Response to Submissions

*SSD-79146716 Pymble Ladies'
College Secondary Innovation
Precinct and Campus Commons*

Director Alaine Roff
Associate Director Rosie Sutcliffe
Consultant Joanna Kontogiorgis & Adrian Leung
Project Code P0054194
Report Number FINAL 18/12/2025

DRAWING
ELEVATION - NORTH
DRAWING NUMBER
AR-SIP-DA-A06-1001
ISSUE
4

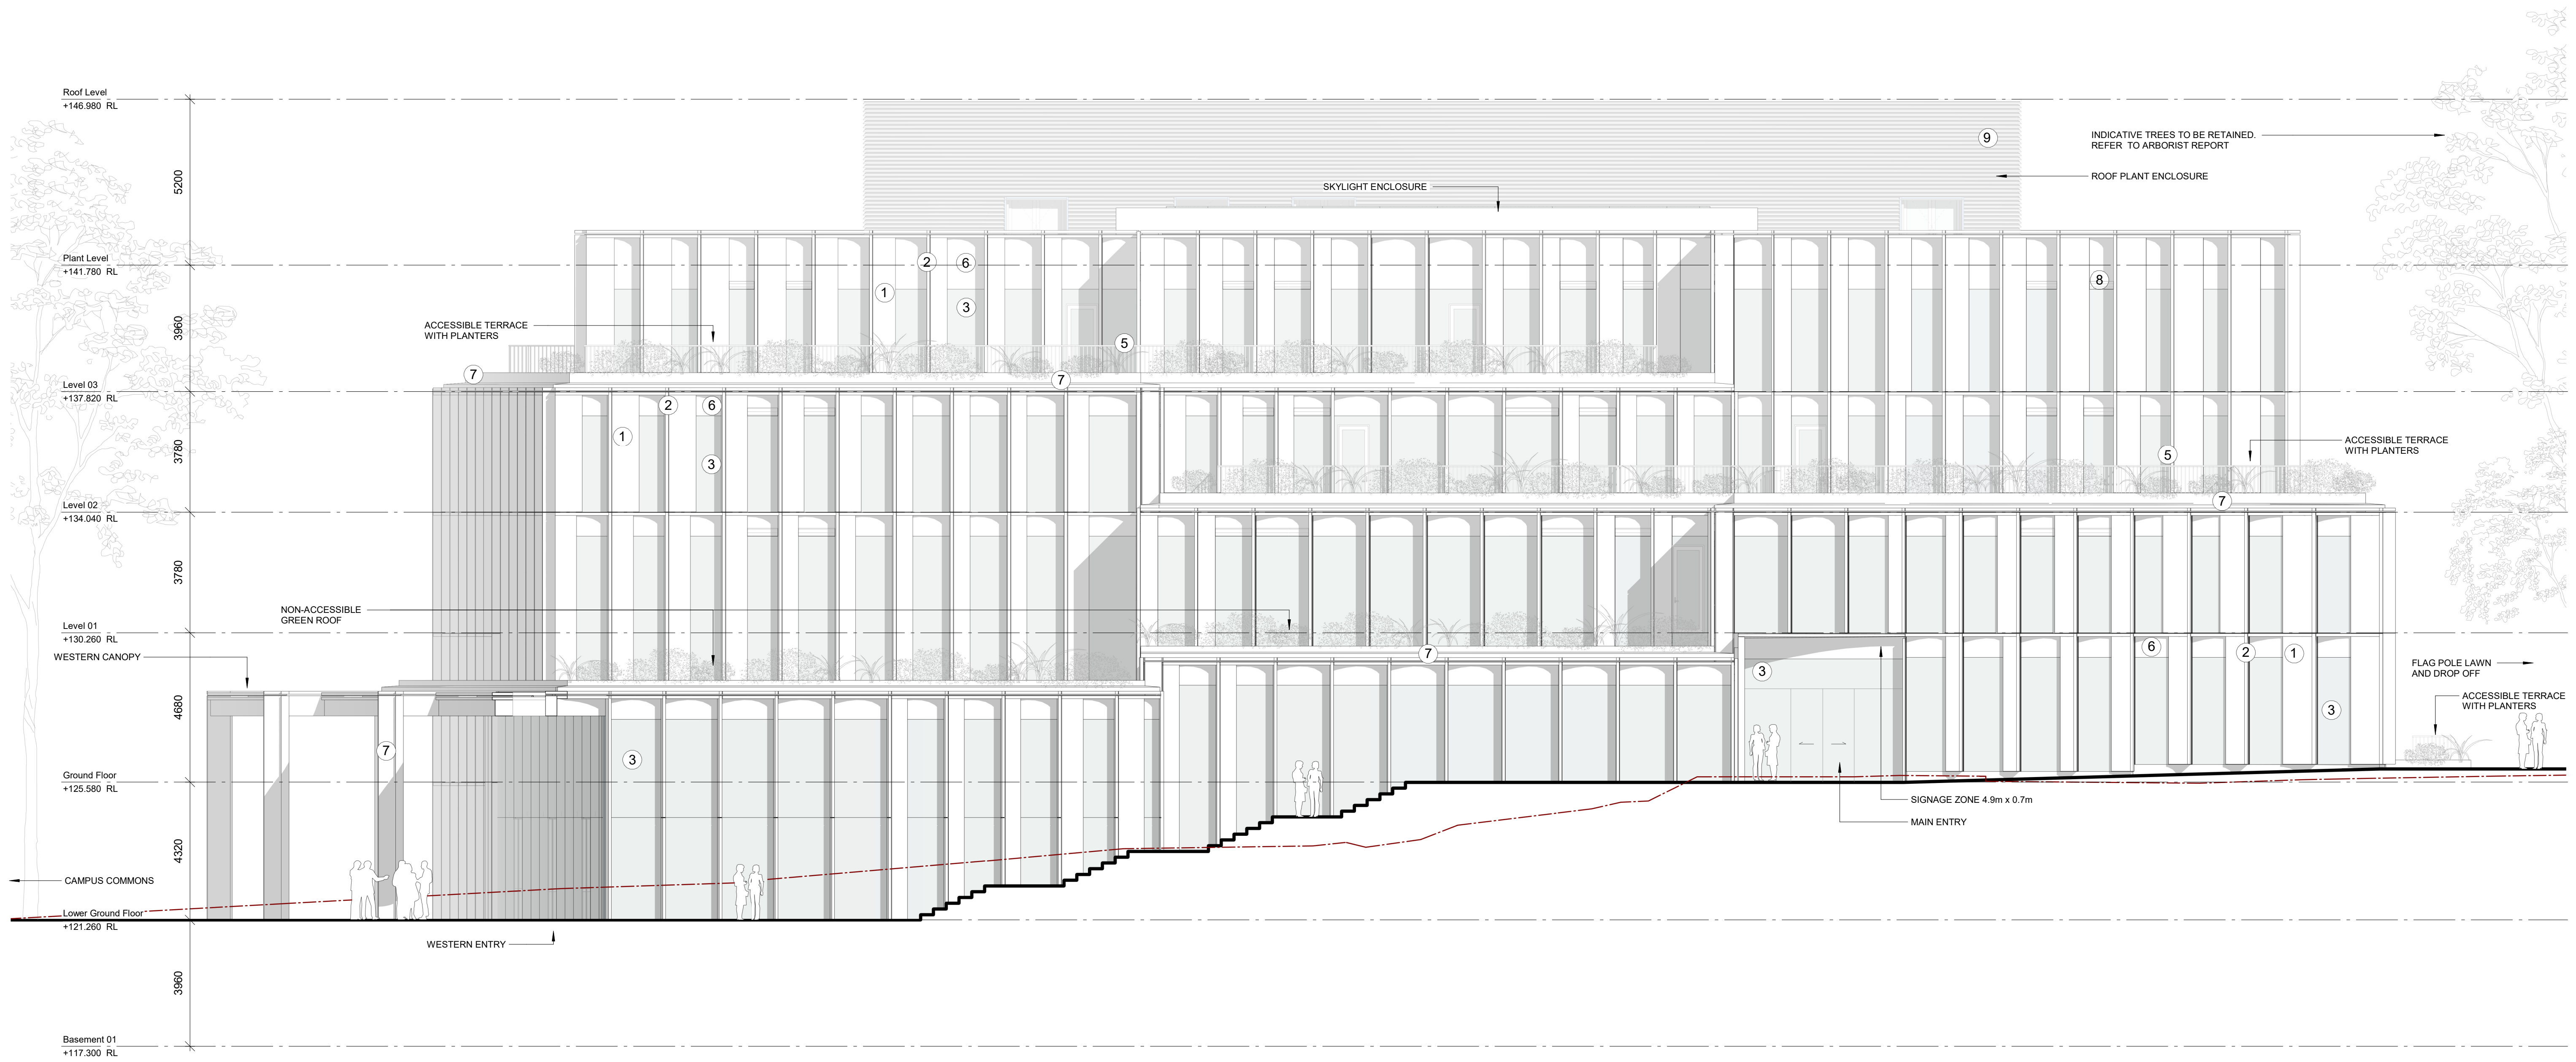
<p>Built Form and Urban Design</p> <p>Council's submission raises concerns about the northern interface to Avon Road, citing excessive height and bulk, limited modulation of the facade, and reliance on vegetation for screening that includes trees proposed for removal. Further, concern is raised with proposed rooftop plant enclosures, shown on the northern edge without setback, which may increase visual prominence.</p>	A response to these issues, as raised by Council, is provided in the 'Ku-ring-gai Council' portion of this table – see below.	Appendix C
<p>The Department recognises that built form impacts along Avon Road are partly screened by existing trees between the proposed Secondary Innovation Precinct (SIP) building and Avon Road. If arboricultural advice supports increased setbacks or modulation to facilitate</p>	<p>As outlined above and elsewhere in this table, further arboricultural and design advice has not supported increased setbacks or modulation to retain high-value trees, due to the significant and excessive nature of change to the building footprint required to retain any additional trees. Arboricultural and ecological advice has not indicated that the retention of the trees in question is necessary.</p> <p>As outlined below, the retained BGHF located between the proposed development and Avon Road will provide sufficient visual buffer to effectively screen the proposed</p>	Appendix C
